**KIRKLEES METROPOLITAN COUNCIL
INVESTMENT & REGENERATION SERVICE**

| Reference No: | 2024/70/92167/W |
| Site Address: | Land off, Edgerton Road, Edgerton, Huddersfield, HD3 3AA |
| Description: | Variation of condition 1 (plans) of previous reserved matters approval 2017/90190 pursuant to outline permission 2014/93014 for erection of residential development comprising of 41 dwellings plus associated works (within a Conservation Area) |

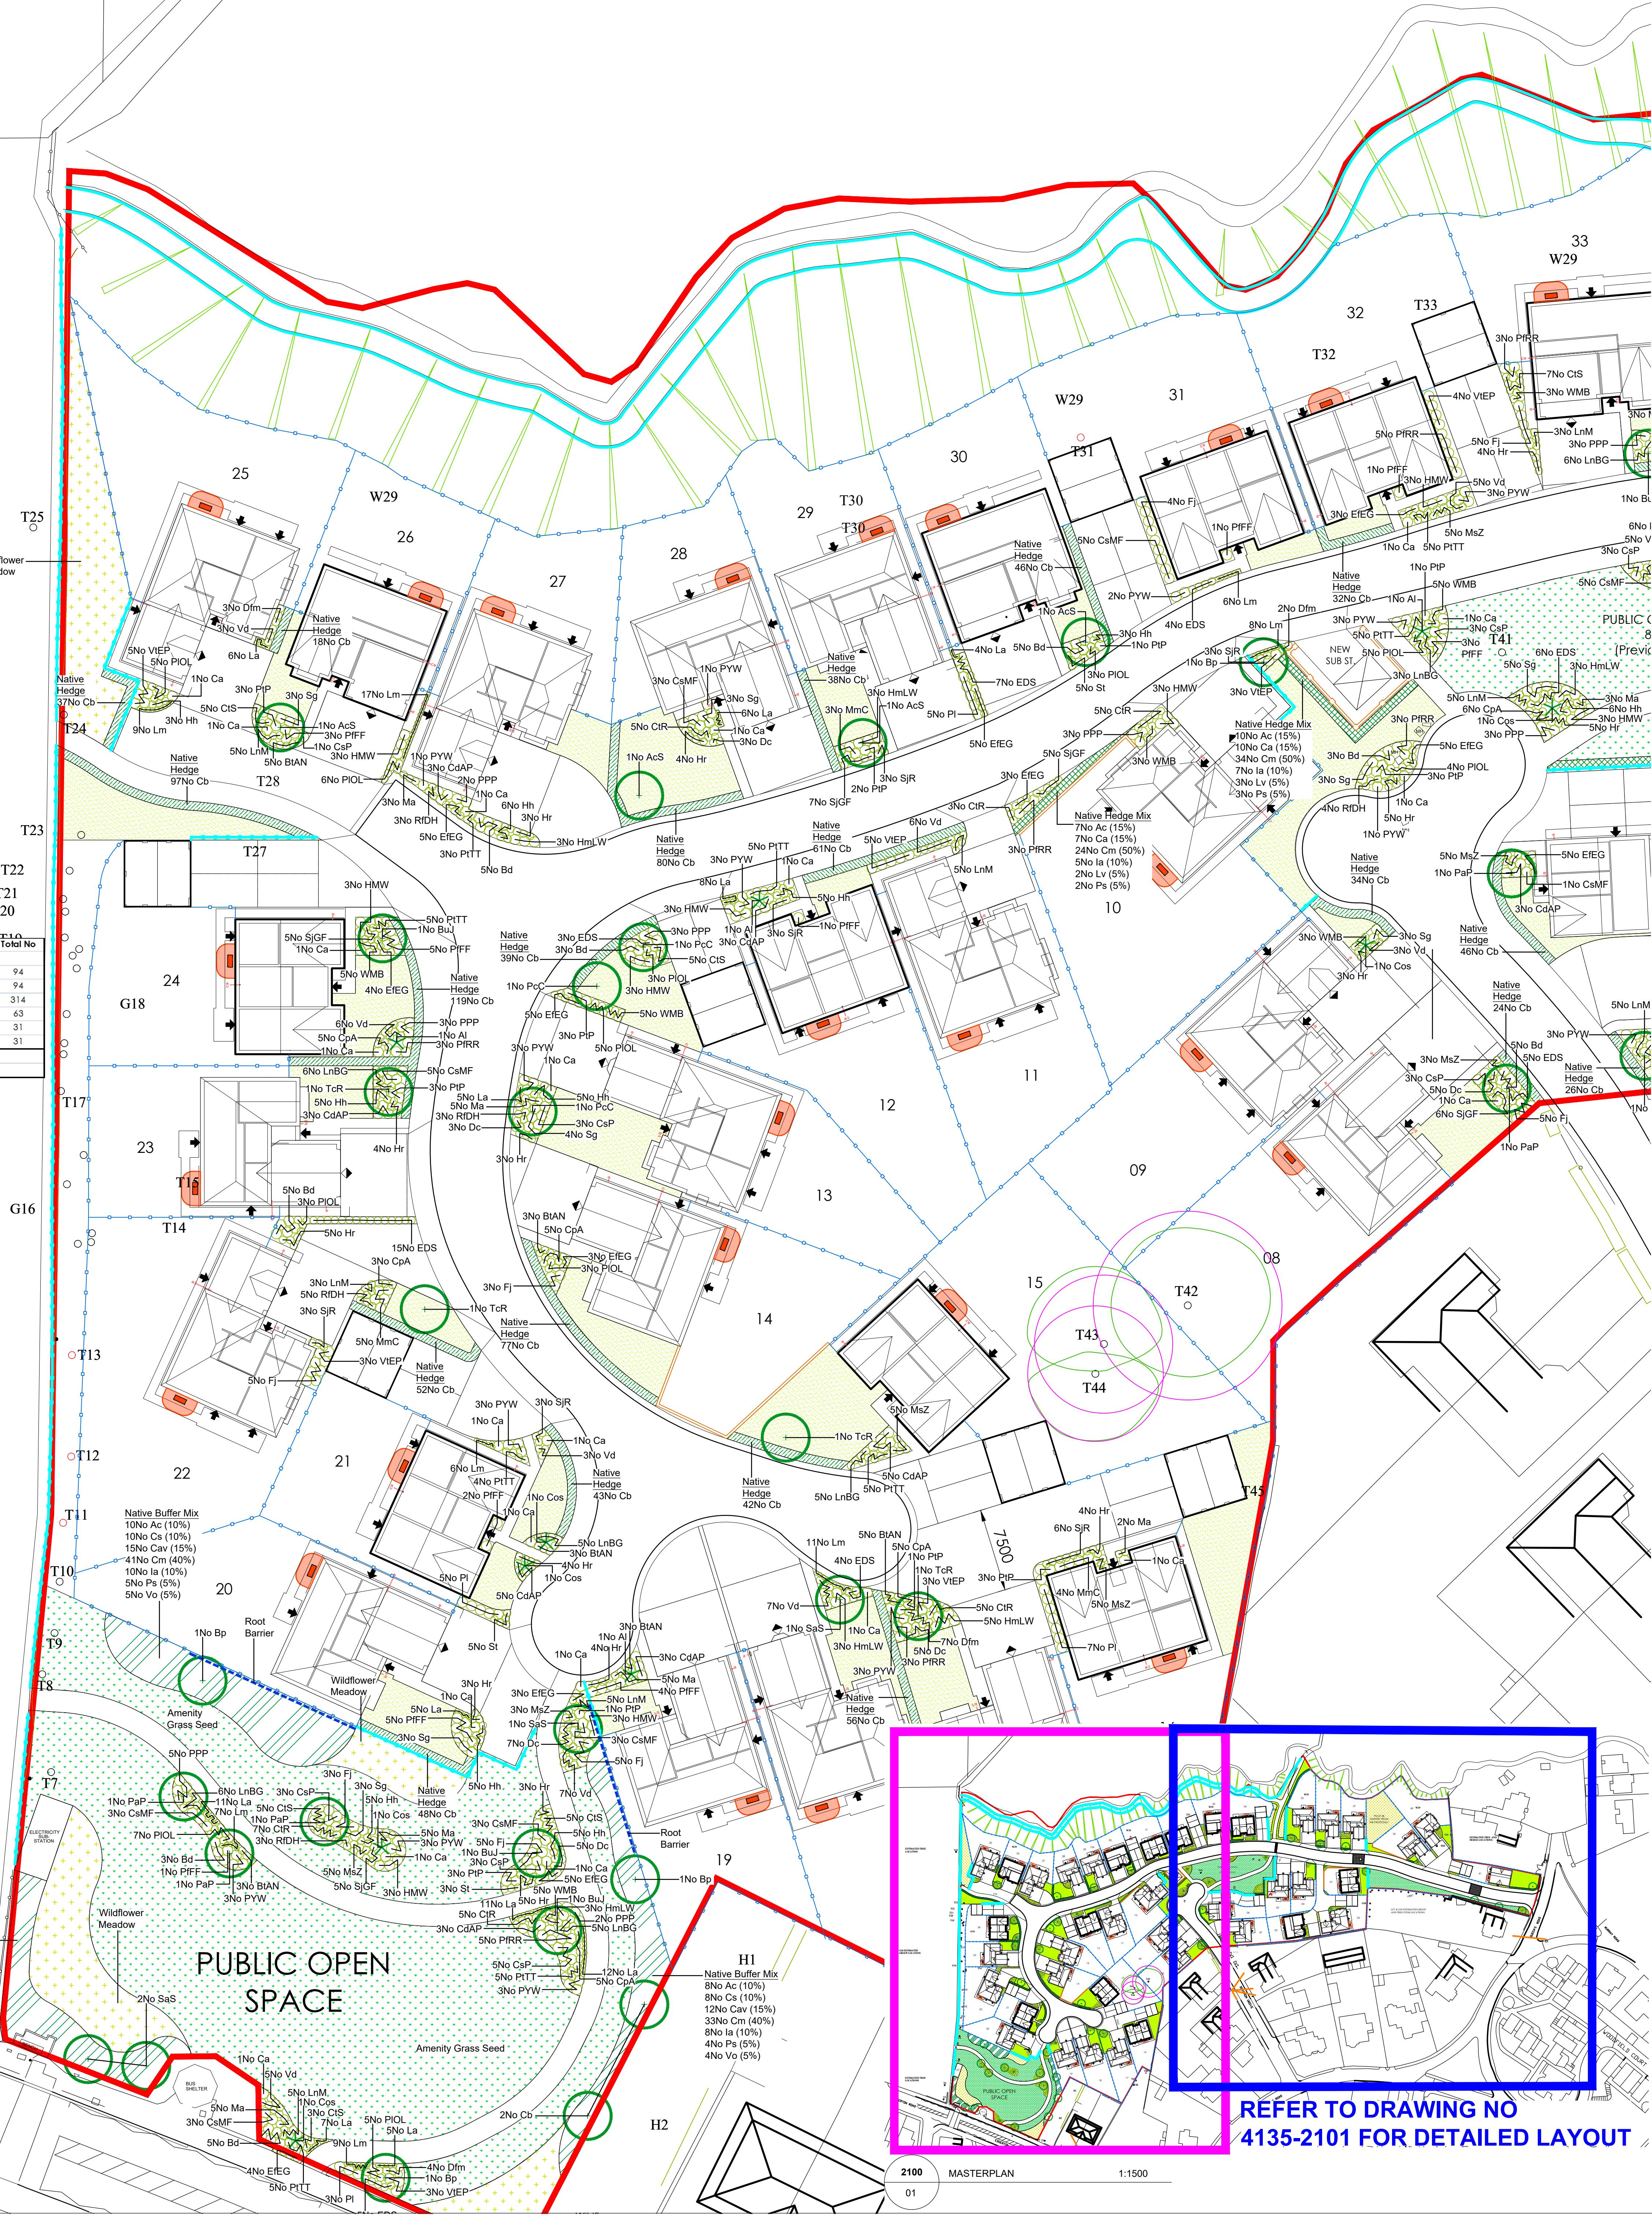
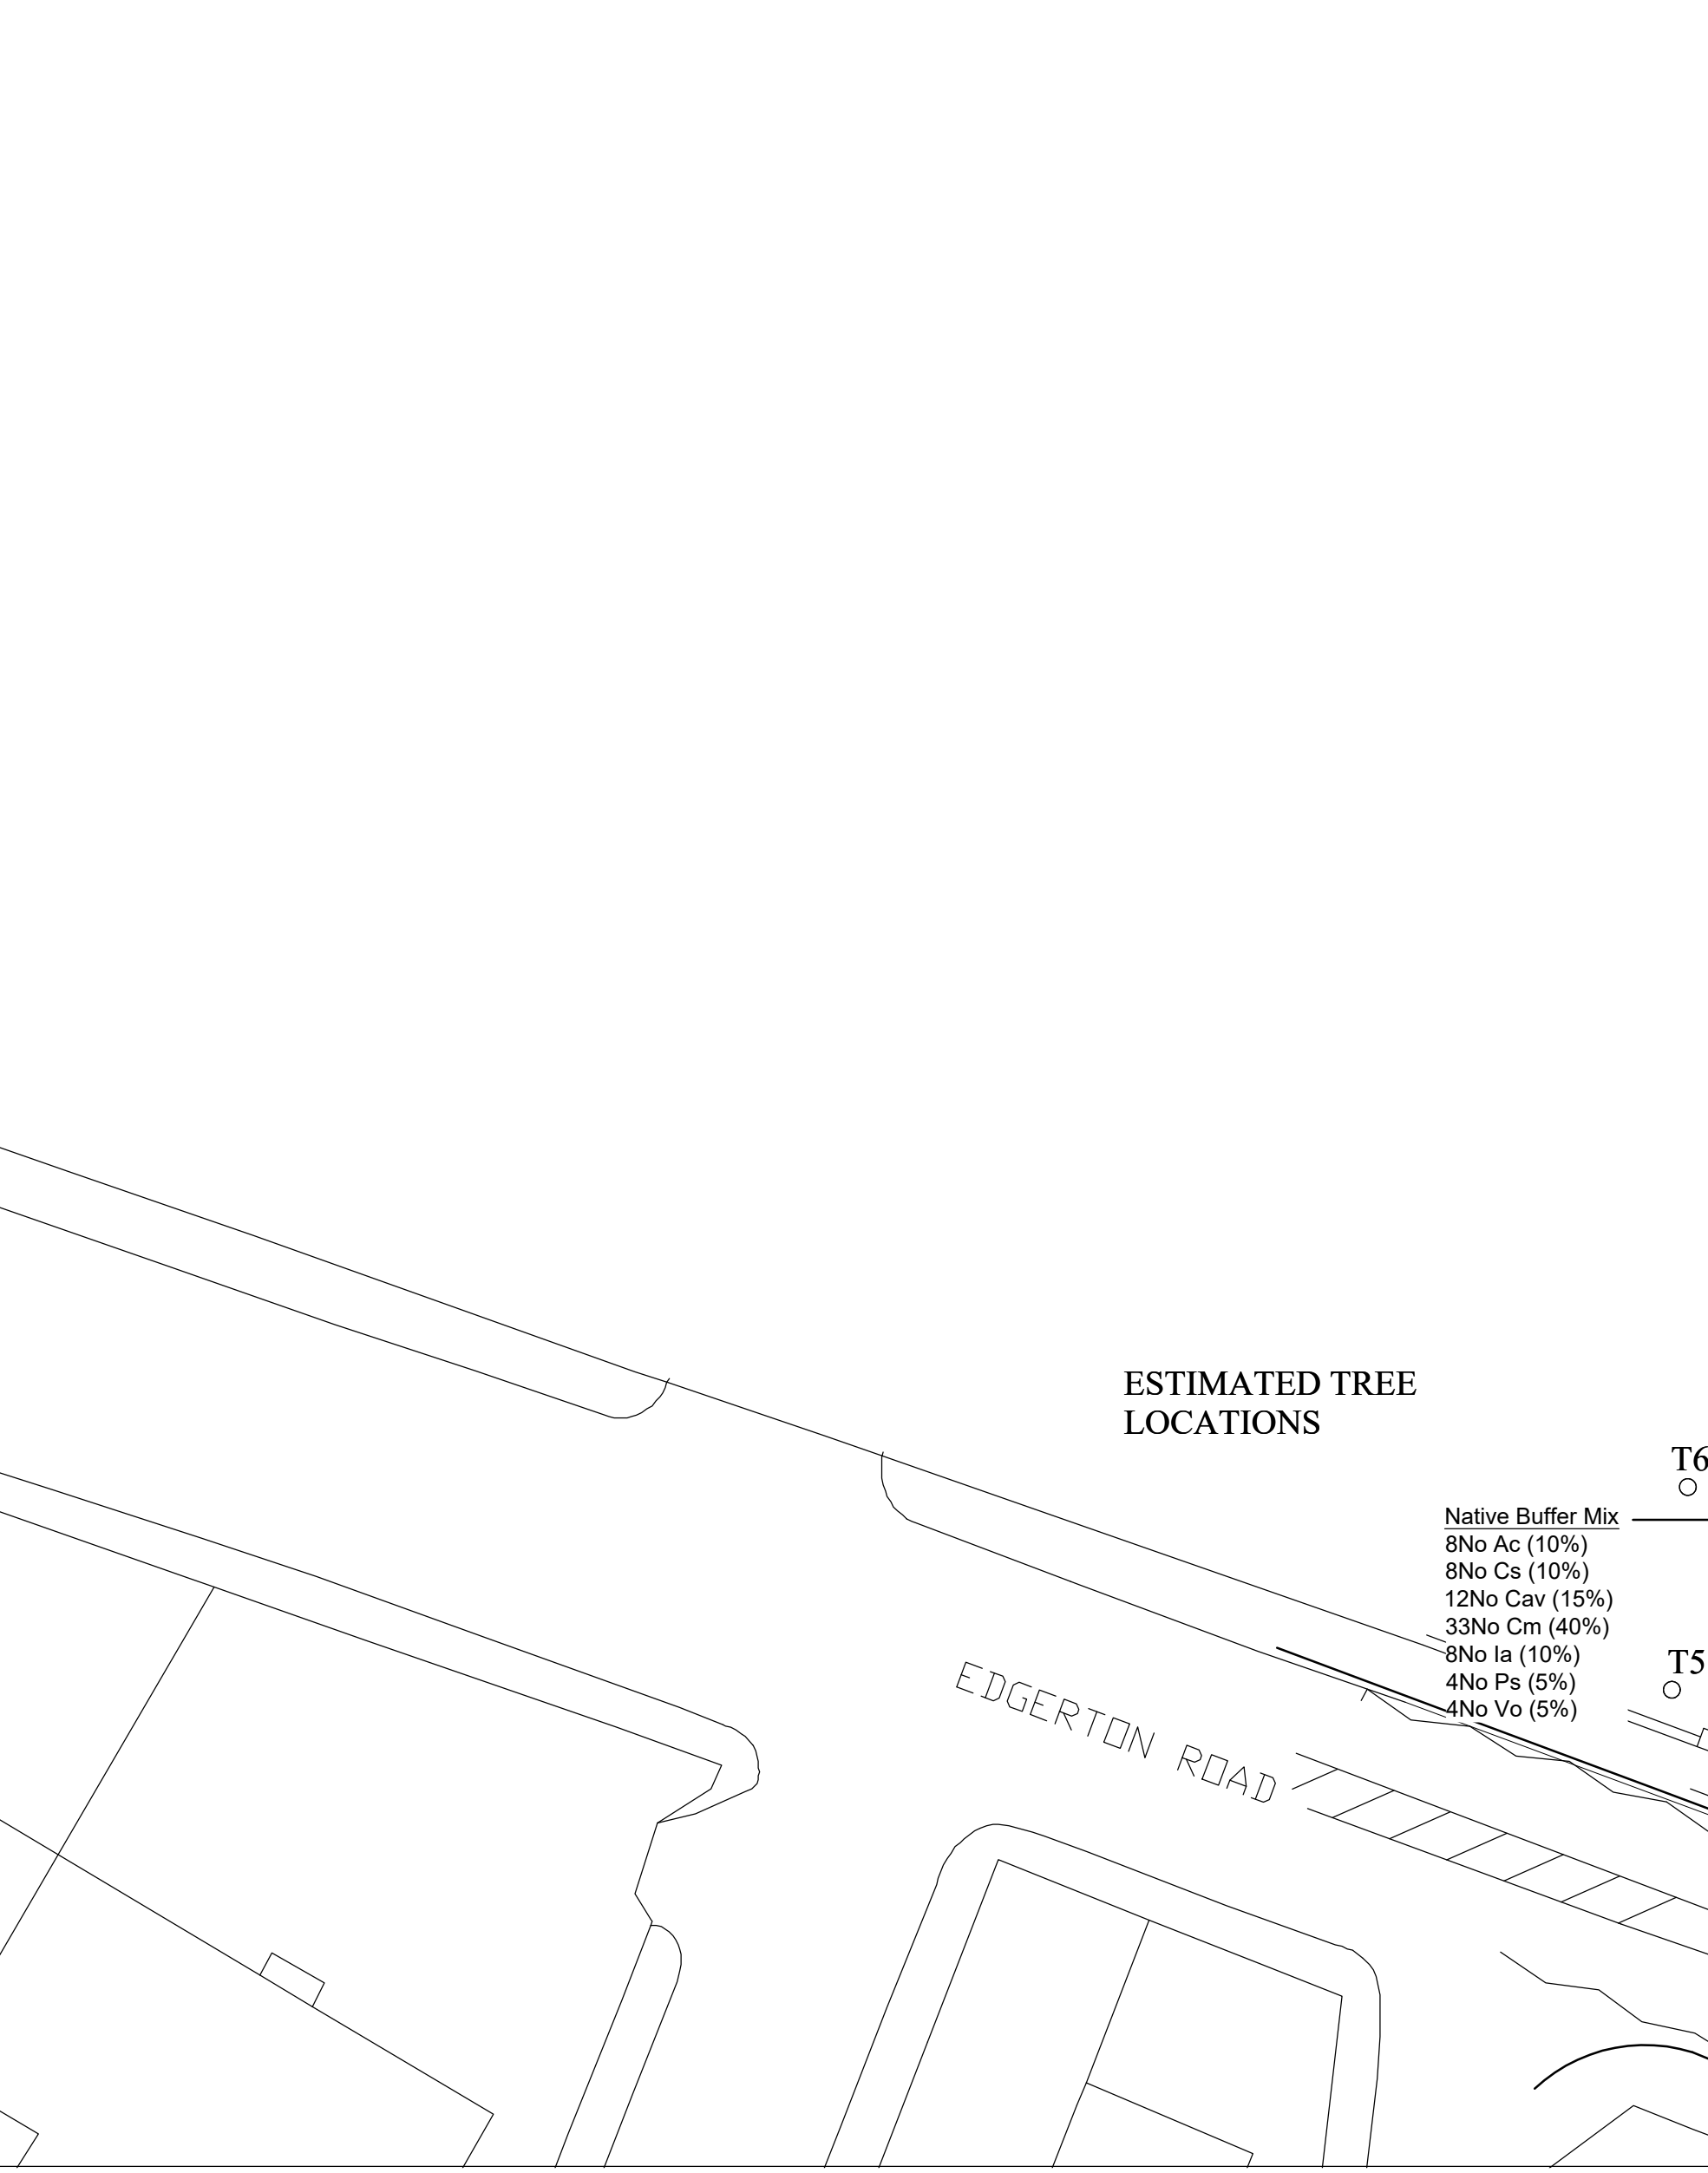
Regarding landscaping, no significant material changes are proposed. Due to the nominal layout changes, the central POS area would increase in size by 10sqm, which is welcomed. Beyond this, the proposed house-type changes and corresponding nominal layout alterations to units would not result in many changes. All trees previously intended to be retained are still to be retained and would be protected via condition 7 (compliance with the Arboricultural Method Statement) which is to be unaltered and remain in force. This would ensure that the setting of the site remains of a verdant nature, ensuring it blends well into the wider Edgerton Conservation Area. The new planting arrangements would be suitably similar that previously approved and remain at a high standard, except for to the rear of plots 20-24. As approved, this was to be turfed with three trees: as proposed, nothing is shown. This is assumed

to be an error, as prior to amendments being made as part of this application, the current proposal sought to include the land behind plots 20-24 within their gardens. On the original scheme, this strip of land was kept out of gardens as a buffer zone to PROW HUD/345/20. To preserve the attractiveness of the PROW, officers requested that the previous arrangement be reverted to, which the applicant acquiesced to. To ensure suitable landscaping along this strip, a condition for landscaping details specific to this area is recommended.
